Re: Falcon Marketplace Preliminary Plan (SP-17-001) Response 4

Please accept this response letter to your review comments dated July 7, 2017.

Preliminary Drainage Report (PDR) / Drainage Plans

**POND #1 (SR4)
DETAILS**

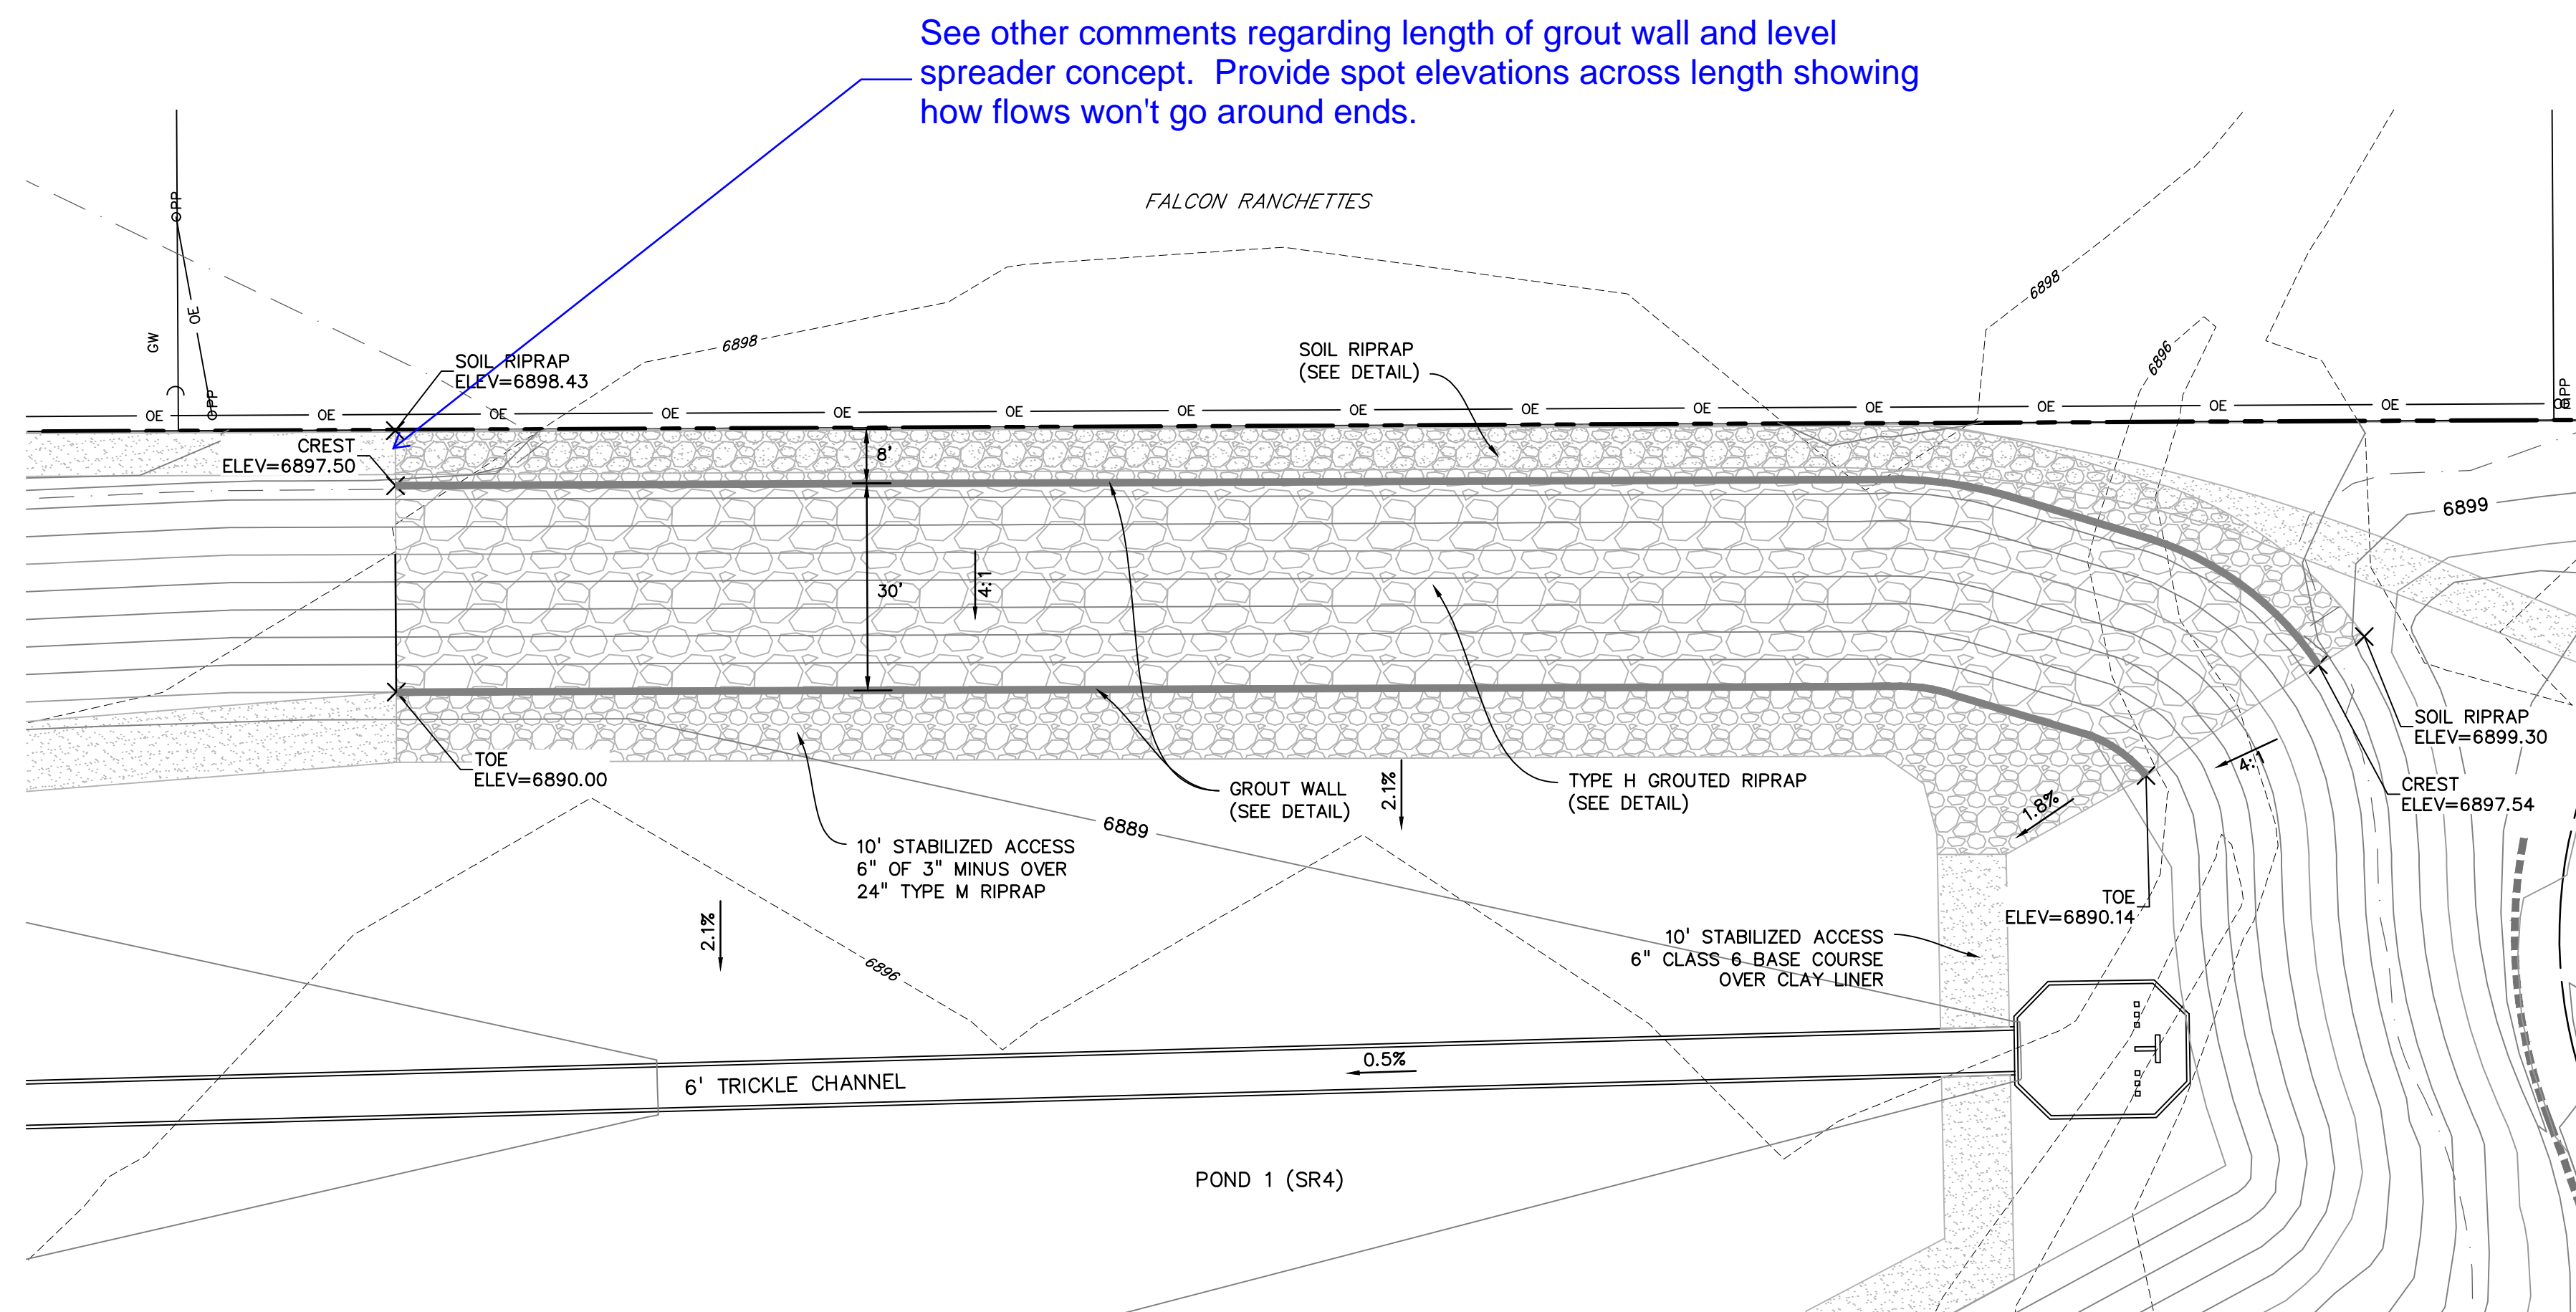
17. Provide a detailed liner design drawing with elevations and extents. Ensure that conflicts with the other pond features are addressed. Partially resolved; see redlines regarding conflicts and cover depth. **See updated details.**
